The Sizewell C Project

5.5 Two Village Bypass Flood Risk Assessment Addendum

January 2021

Plate 6.20. Difference in flood depth – 1 in 100-year event with 35%CC

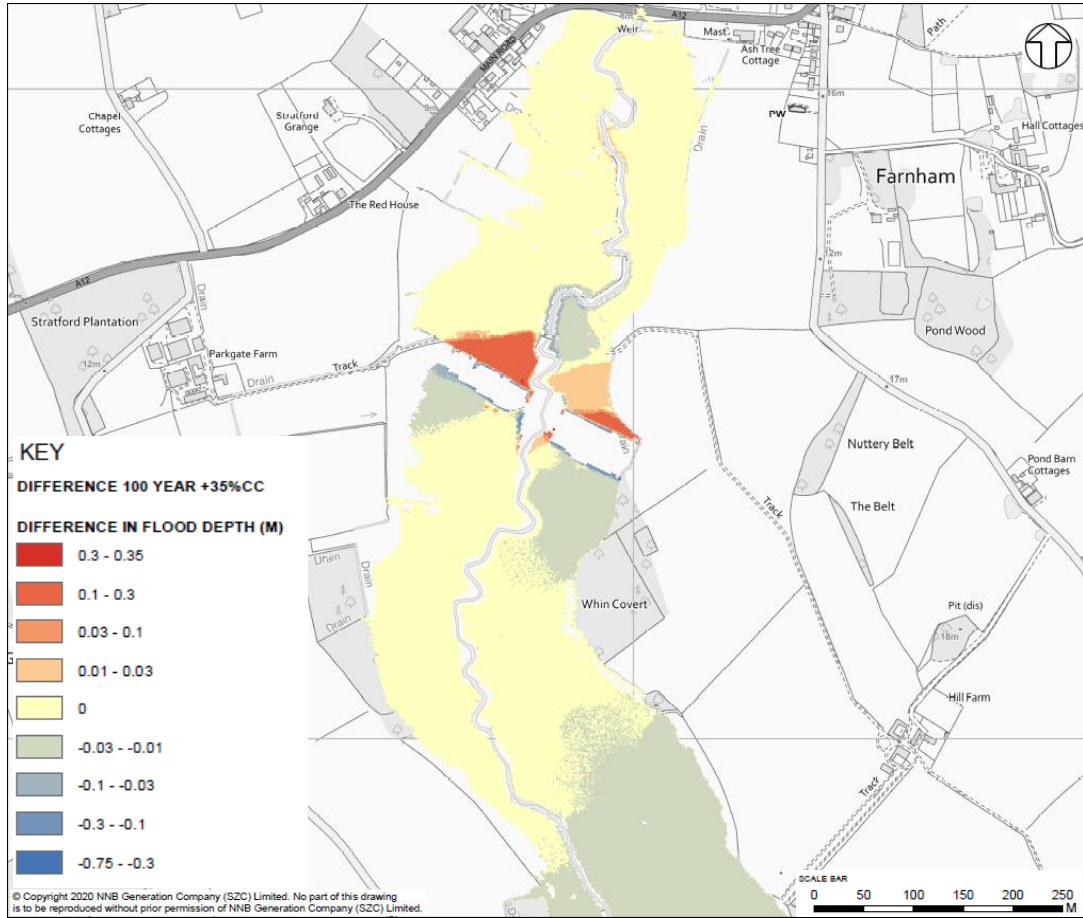
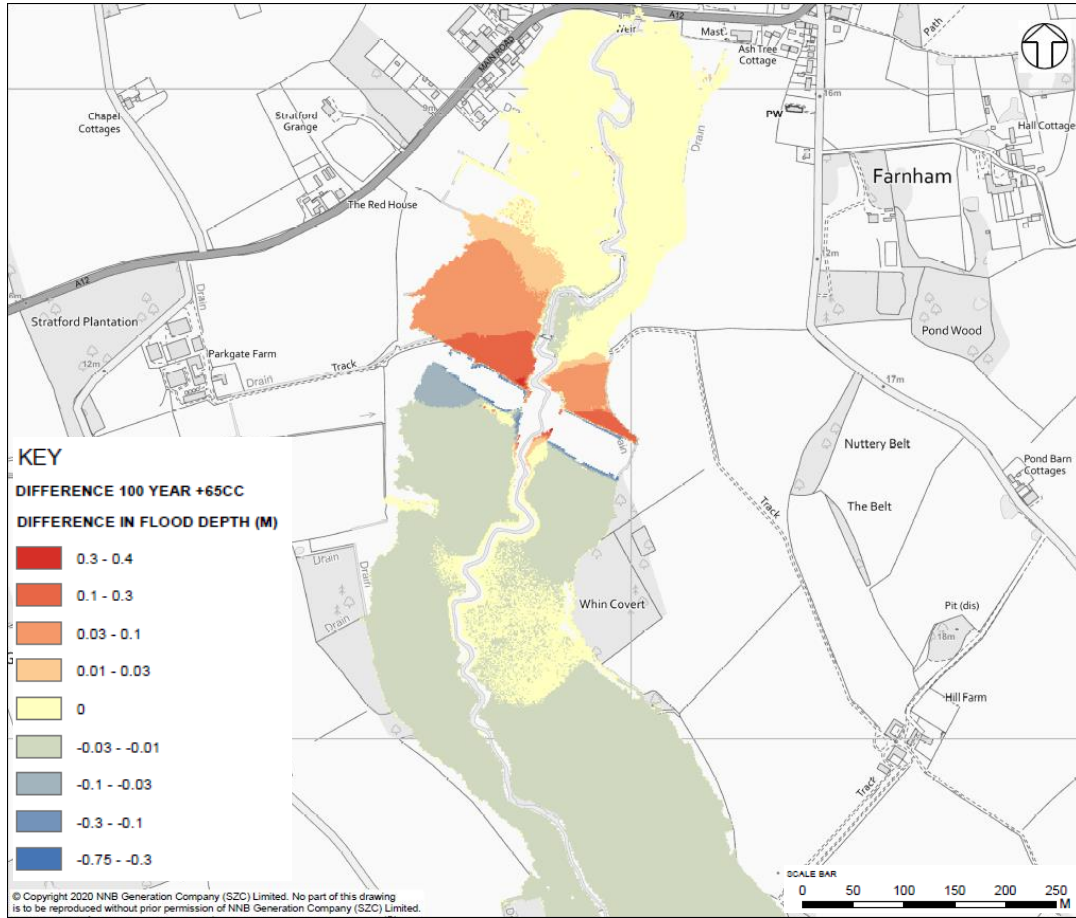
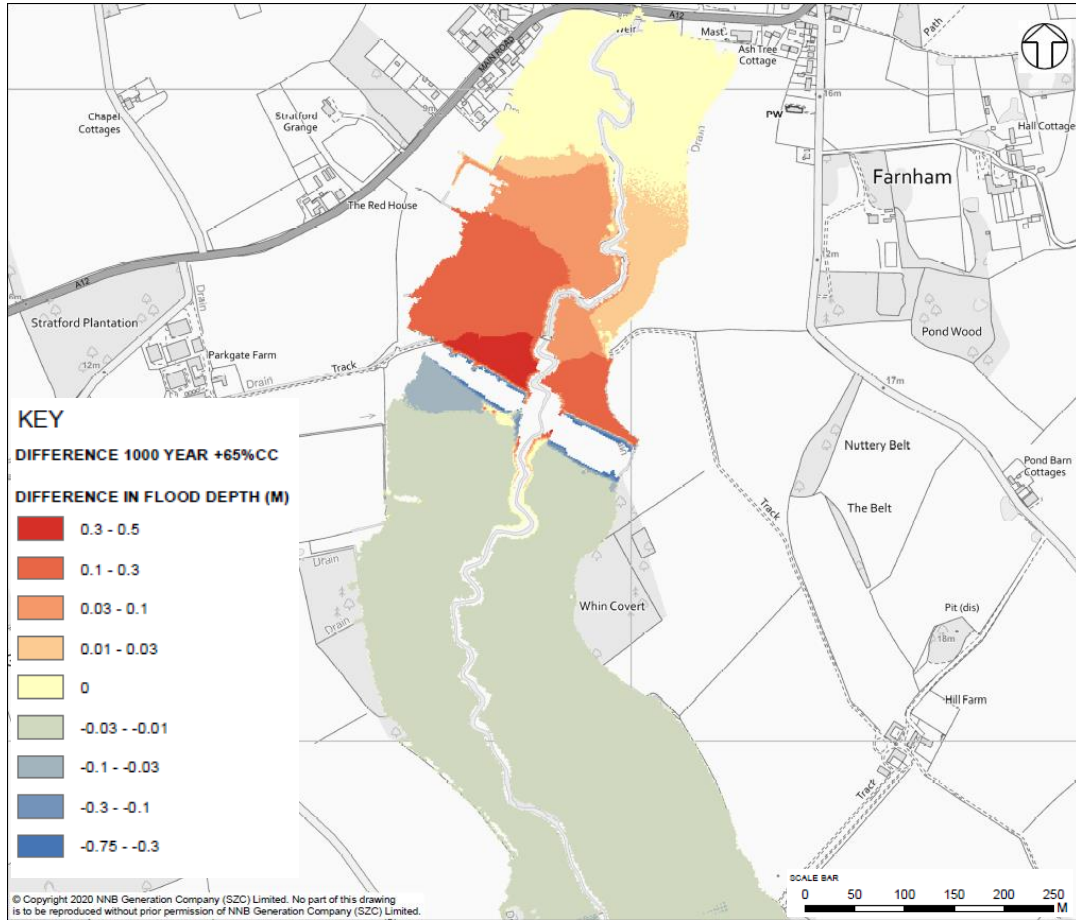
"The FRA has assessed fluvial flood risk and demonstrated some localised areas of increased depths as a result of the proposals. Confirmation of written consent from the landowner must be included in the FRA that they accept the increased flood depth, hazard and velocity on their land in order for this to be acceptable without further mitigation as required by EN-6 3.6.16."
- 2.1.2 The **Two Village Bypass Flood Risk Assessment** (Doc Ref. 5.5) [[APP-119](#)] confirmed that, following review of all sources of flooding there would

- 2.1.3 While there was a slight increase in flood risk, the impact was concluded as being very low, as it was very localised in nature i.e. immediately upstream of the proposed bridge crossing over the River Alde and only affected low-lying areas of agricultural land that were already at risk of flooding. These results were presented as Plates 6.20 – 6.22 in **Appendix A: Two Village Bypass Modelling Report** (Doc Ref. 5.5) [[APP-120](#)].

- 2.1.4 Whilst the Environment Agency acknowledged that the impact of flooding was low, they also requested that agreement be sought with the landowner affected by the localised increase in flood depth to confirm that the increase in risk was accepted.

- 2.1.5 SZC Co. is currently in talks with and will continue to engage with the landowner of the affected area, with the view to obtaining confirmation that the increased flood depth, hazard and velocity is accepted.
